PROPOSED RESIDENTIAL DEVELOPMENT

LANDS BECK WAY

Statement of Community Involvement - Responses

Plot 19
4 bed 2 ½ Storey
81m² + 71m² + 28m² + 18m²
180m² (1935ft²) + Garage
Footprint 116m²

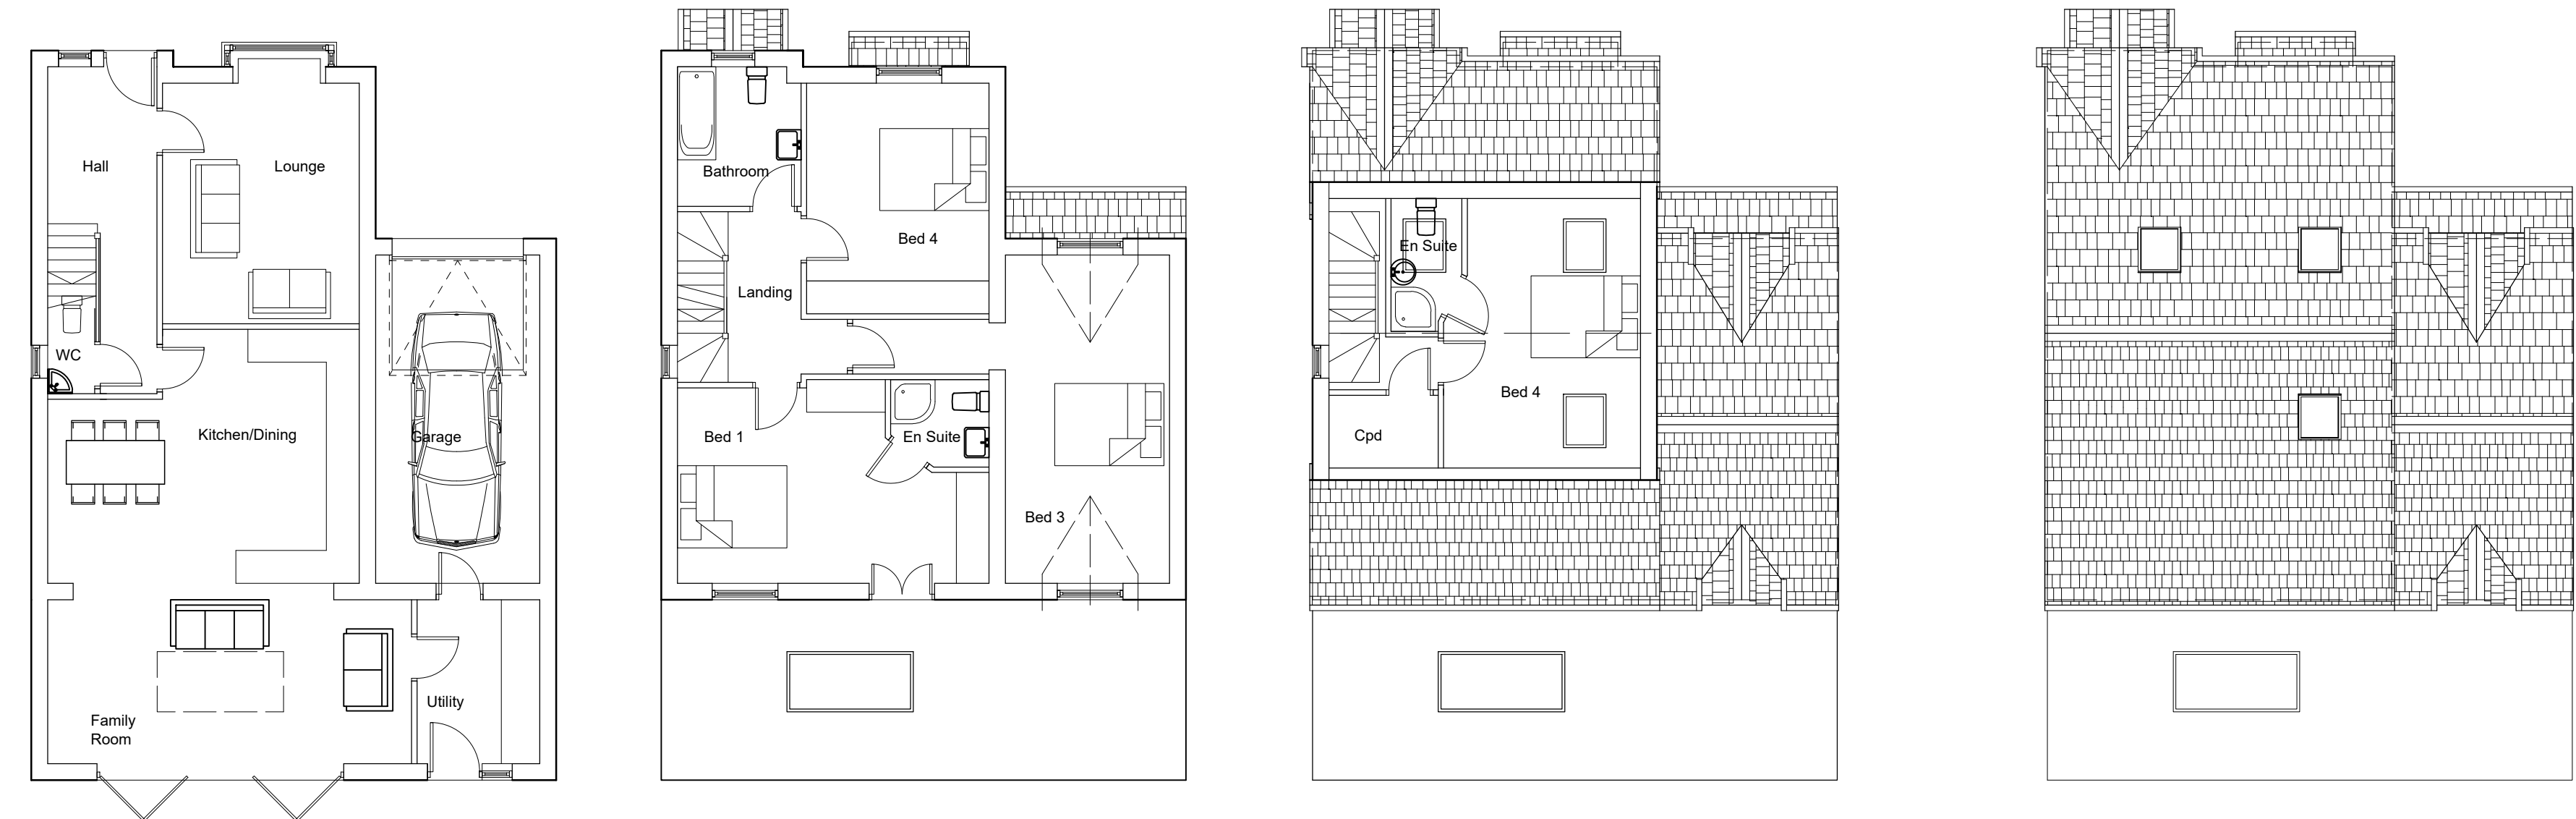
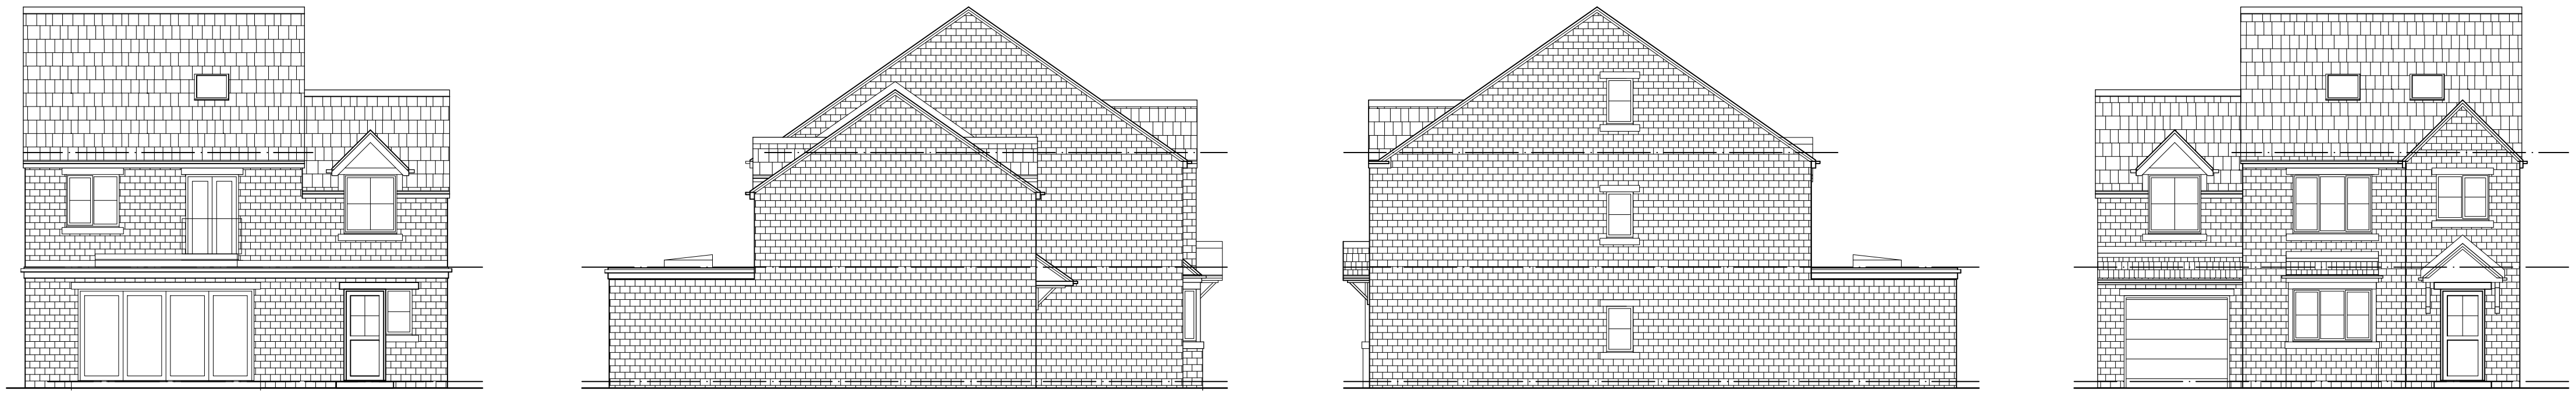
Second, there is a lack of symmetry in the new development when compared to existing properties on the road: all four properties currently leading down to the cul-de-sac are offset from the road by several metres, whereas the new properties proposed to border Lands Beck Way will be situated very close to the boundary. There is also a lack of symmetry with the existing bungalow at 257 Halifax Road. We feel that moving the proposed development in line with 257 Halifax Road, at the same time giving plots 1, 13 and 19 a bigger offset, would be more in keeping with the existing surroundings.
